Our ref: STH17/00123/04  
Contact: Andrew Lissenden 4221 2769  
Your ref: SSD 8640

12 June 2018

**STATE SIGNIFICANT DEVELOPMENT 8640 – LOT 2 DP 520158 (NO.480) ARGYLE STREET, PICTON - PICTON HIGH SCHOOL REVELOPMENT**

Project Name	PICTON HIGH SCHOOL REDEVELOPMENT PICTON, NSW 2571
Drawing Title	ARGYLE STREET TRAFFIC CONTROL DEVICE SKETCH PLAN

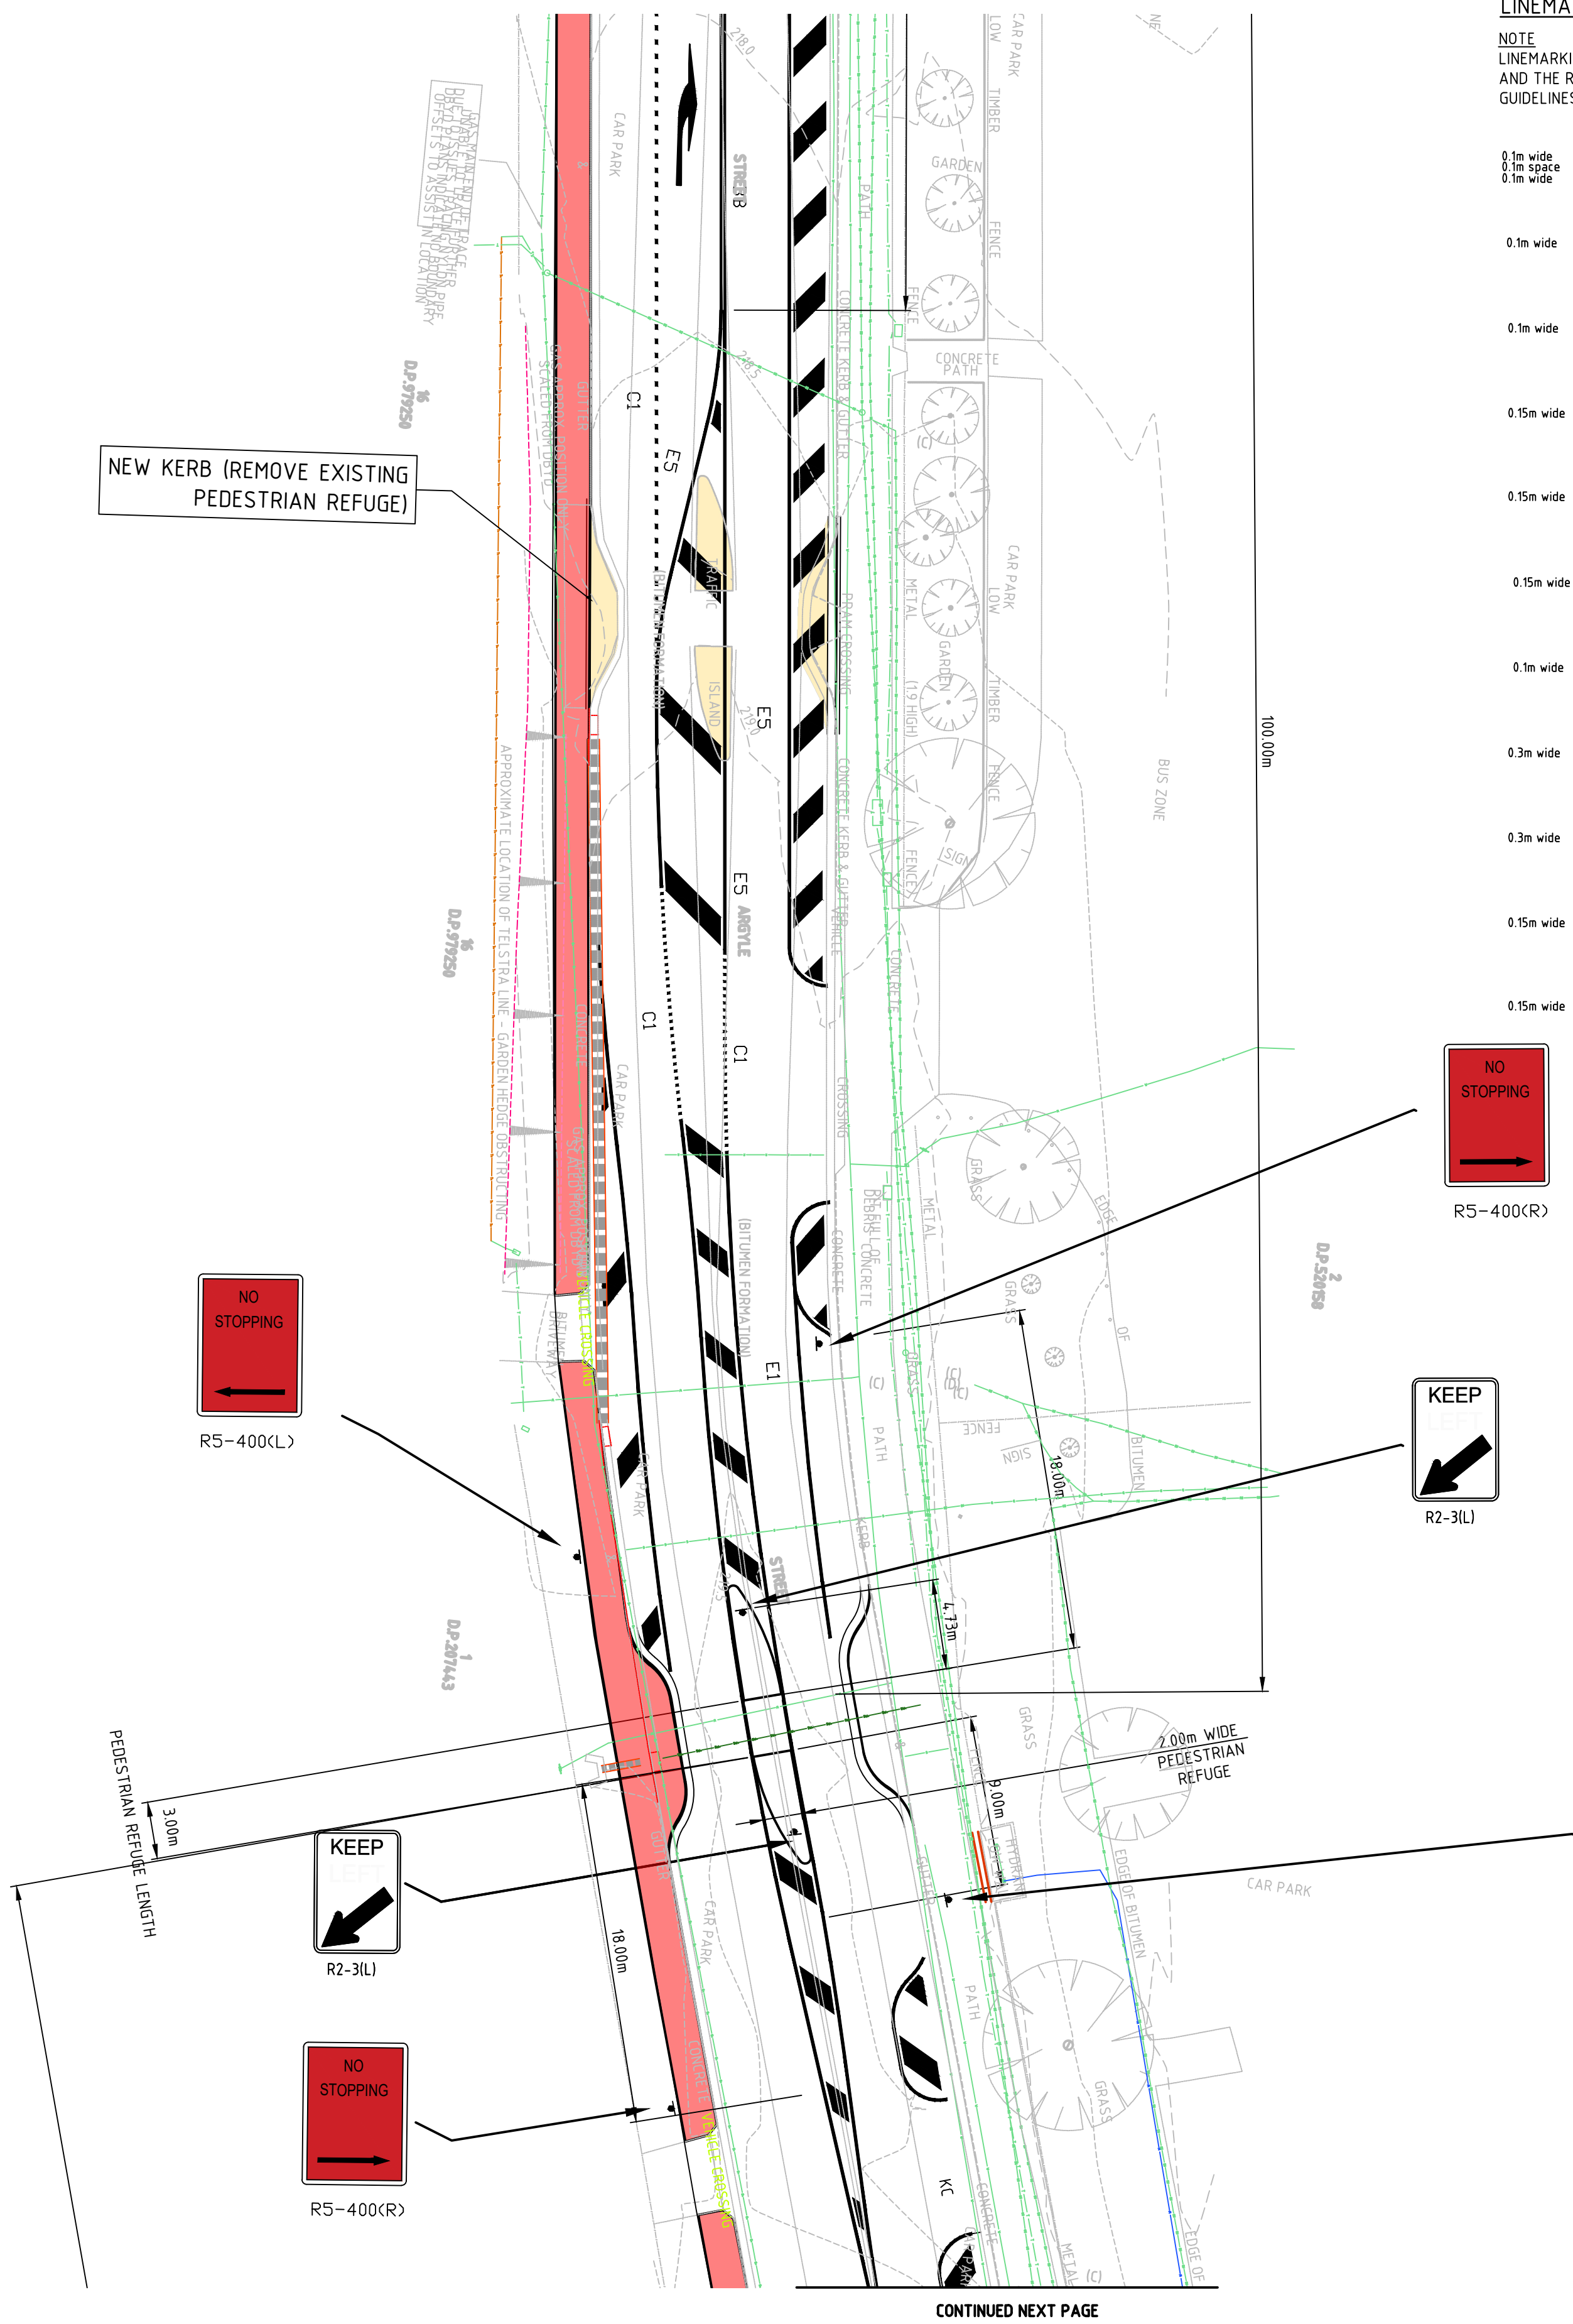
- Level of Details: As outlined in pre lodgement advice that has been provided by RMS, concept plans for the proposed works in Argyle Street that contain a greater level of detail should be provided. These plans should be to scale, and include but not be limited to, legal lot/road reserve boundaries, existing line marking, proposed new line marking, new signage, location of existing infrastructure (i.e. power poles, light poles, etc), road carriageway/lane widths at various locations, measurements for all new proposed infrastructure (e.g. length and width of turn bays, pedestrian thresholds), etc. This level of detail is required so as to demonstrate compliance with relevant standards, to ensure the proposed/required works can fit within the existing road reserve area or if they cannot what changes are required and to enable Council to undertake an assessment of impacts as well compliance with applicable Austroads requirements. At this time, what has been submitted are sketch plans that do not contain adequate information to undertake the required assessment as detailed above. As such, the applicant should be requested to provide the above detail to council for review and comment prior to the determination of SSD 8640.

- Roads Act 1993: RMS notes the Environmental Impact Statement details that an approval is not required under the *Roads Act 1993* in order to permit the proposed development to occur (i.e. Table 5). RMS advises that as the current proposal is seeking to undertake work on Argyle Street which is a I classified regional road, these works and/or structures will require consent from council and concurrence from RMS under Section 138 of the *Roads Act 1993*. Generally, should the developer be able to demonstrate to council that a proposed treatment and/ or work on a classified regional road is acceptable and complies with relevant standards, RMS would issue its concurrence to council under Section 138;
